Response to Planning Application

Application ref: BN/139/20/PL

Description: 1 No dwelling. This site is in CIL Zone 3 and is CIL Liable as new dwelling.

Location: The Cottage Highground Lane Barnham PO22 0BT

PROPOSED SITE PLAN & LANDSCAPING

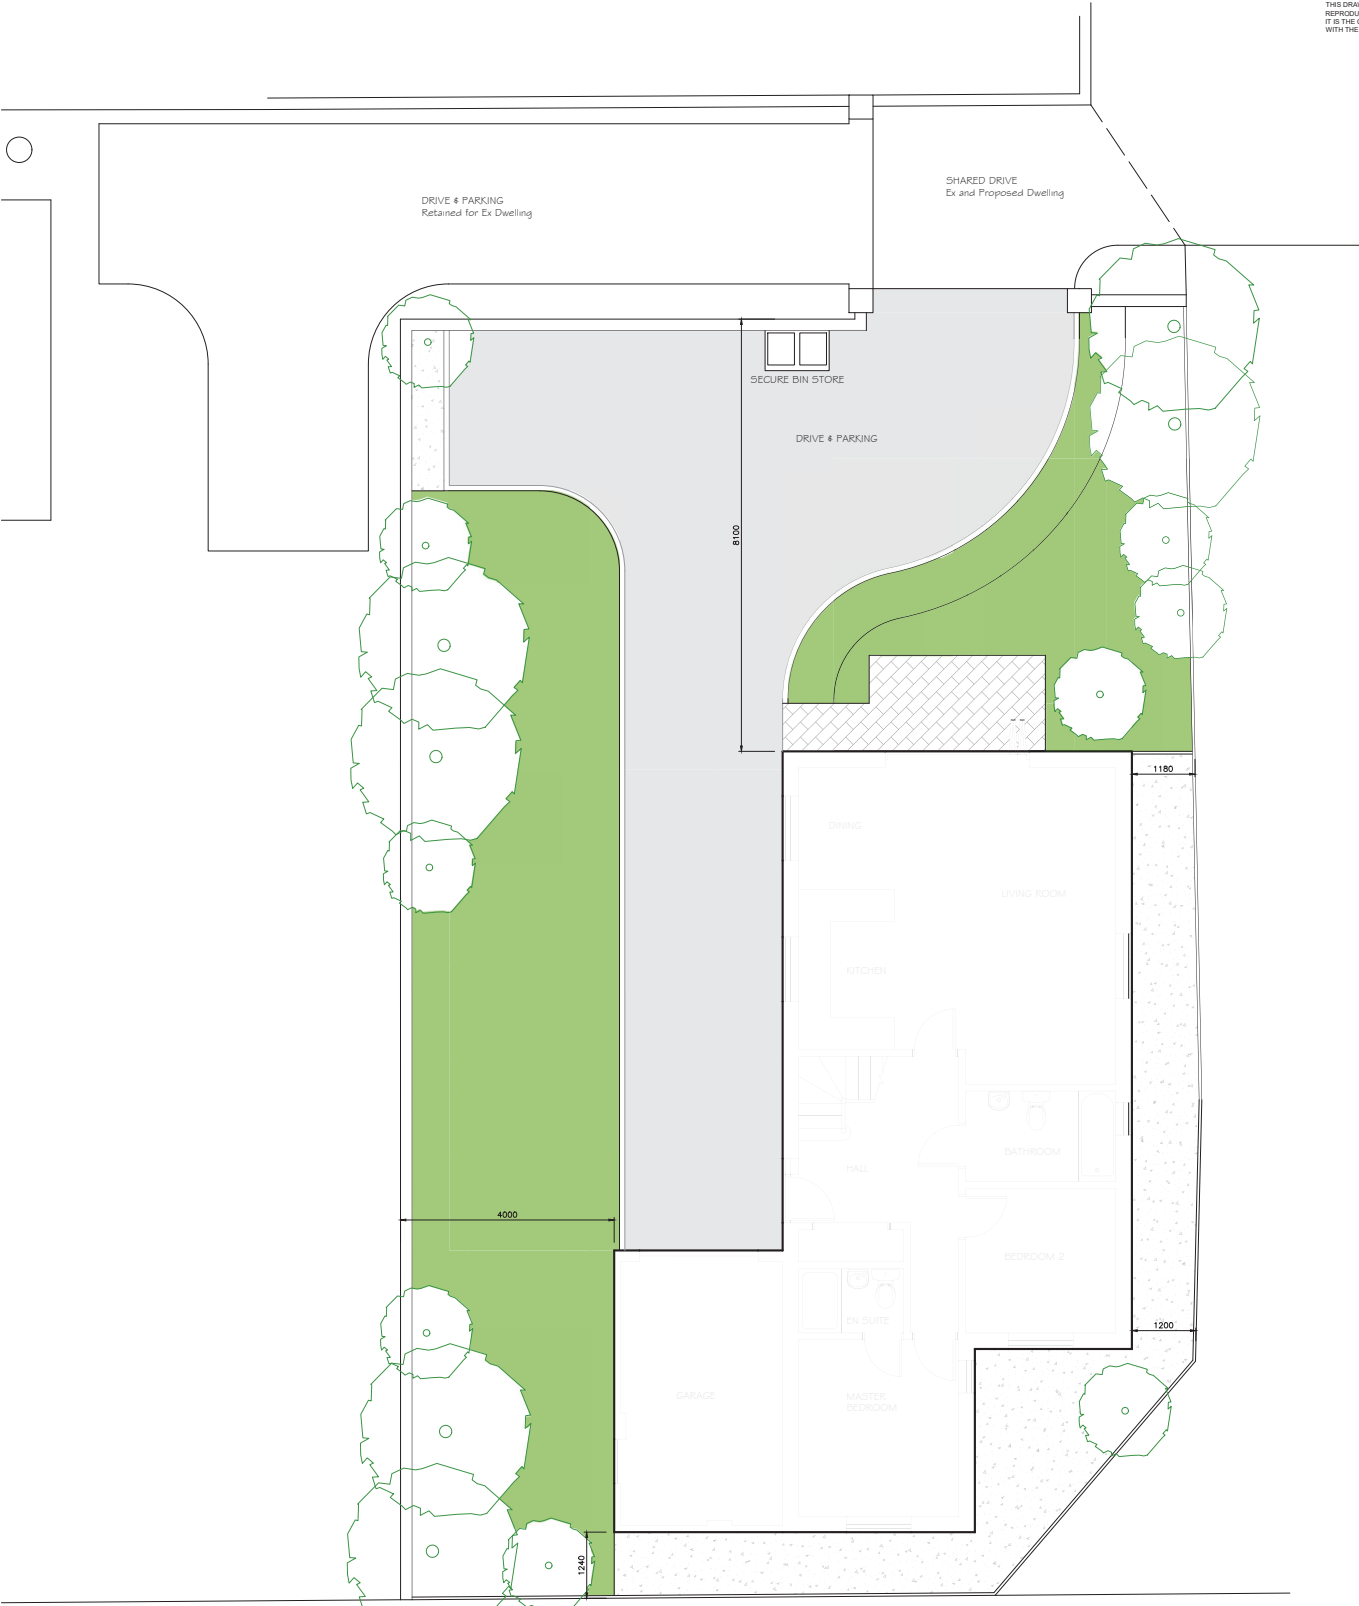
The NPPF para 124/127 relate to good design principles which equally apply to small infill and replacement development. The indicative site layouts show no tree protection plans and has made no detailed reference to existing to be retained trees and shrubs only showing indicative planting alongside the development proposals, but not in sufficient detail as would be required. The information provided in this application would require expanding in the form of a detailed planting plan and specification detailing species choice, actual plant quantities, planting densities and size at time of planting. Detail should also be provided regarding existing trees and boundary planting and the interface this has with the proposals.

Landscape provision to the dwelling and improvement with native species infill plus further boundary screening as required. All proposed planting should be considered and its connection for biodiversity and habitat explored, with a biodiversity net gain following development. Trees specified should be at a size which allow instant impact, but which will establish and mature as the site develops.

I would not be able to recommend landscape support of the application at this stage until further landscape detail is submitted for approval. Landscape details will need to show ornamental and native improvements with biodiversity net gain, along with tree protection methods in relation to within and beyond the site boundary that may be affected by the development proposals.
